CITY OF ALBUQUERQUE

February 9, 2021

Re: **Route 66 Veterinary E.R. and Critical Care Center**
3601 Central Av, NE
Traffic Circulation Layout
Architect's Stamp date ----- (K17D064)
Via email doug@mullenheller.com

Traffic Circulation Layout

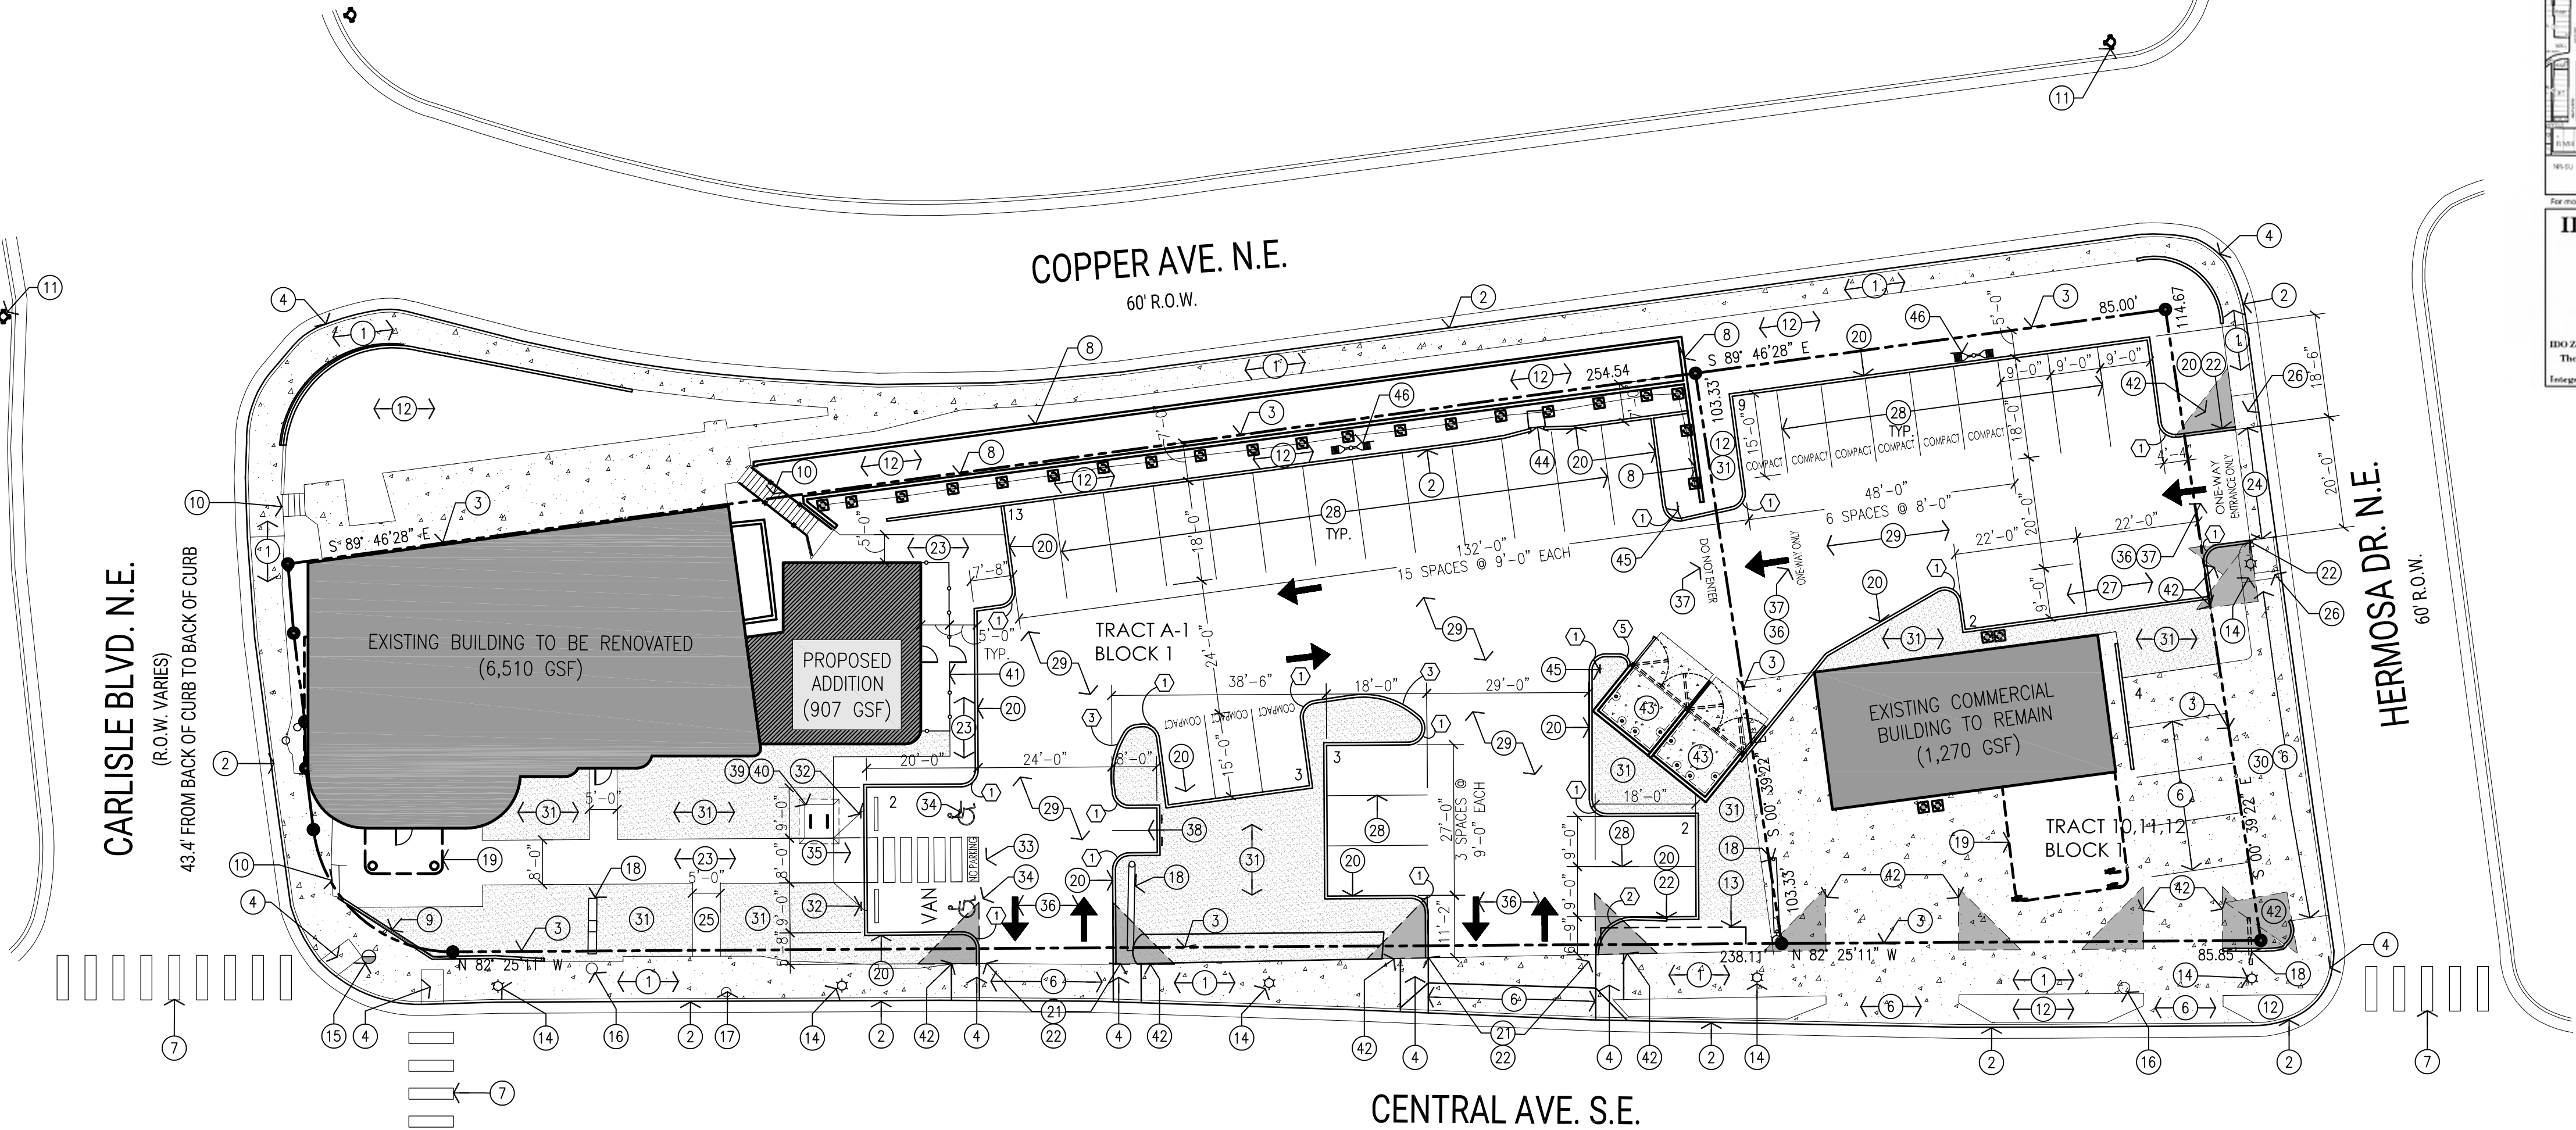
1. Provide a Traffic Scoping Form or approved Traffic Impact Study for the development.
2. Provide shared access agreement for the adjacent property to the east.
3. Fire and emergency access: Provision for access by fire and emergency vehicles needs to be in accordance with the Albuquerque Fire Plan Checking Division. Provide approval from the Fire Marshall.
4. Add Do Not Enter sign for the one-way driveway on Hermosa.
5. Provide sign face detail drawings for; ADA parking, Motor Cycle parking and Do Not Enter signs.
6. Provide bicycle parking rack details.
7. Show motorcycle parking sign location.
8. Plans must be sealed and signed by a licensed NM RA or PE.
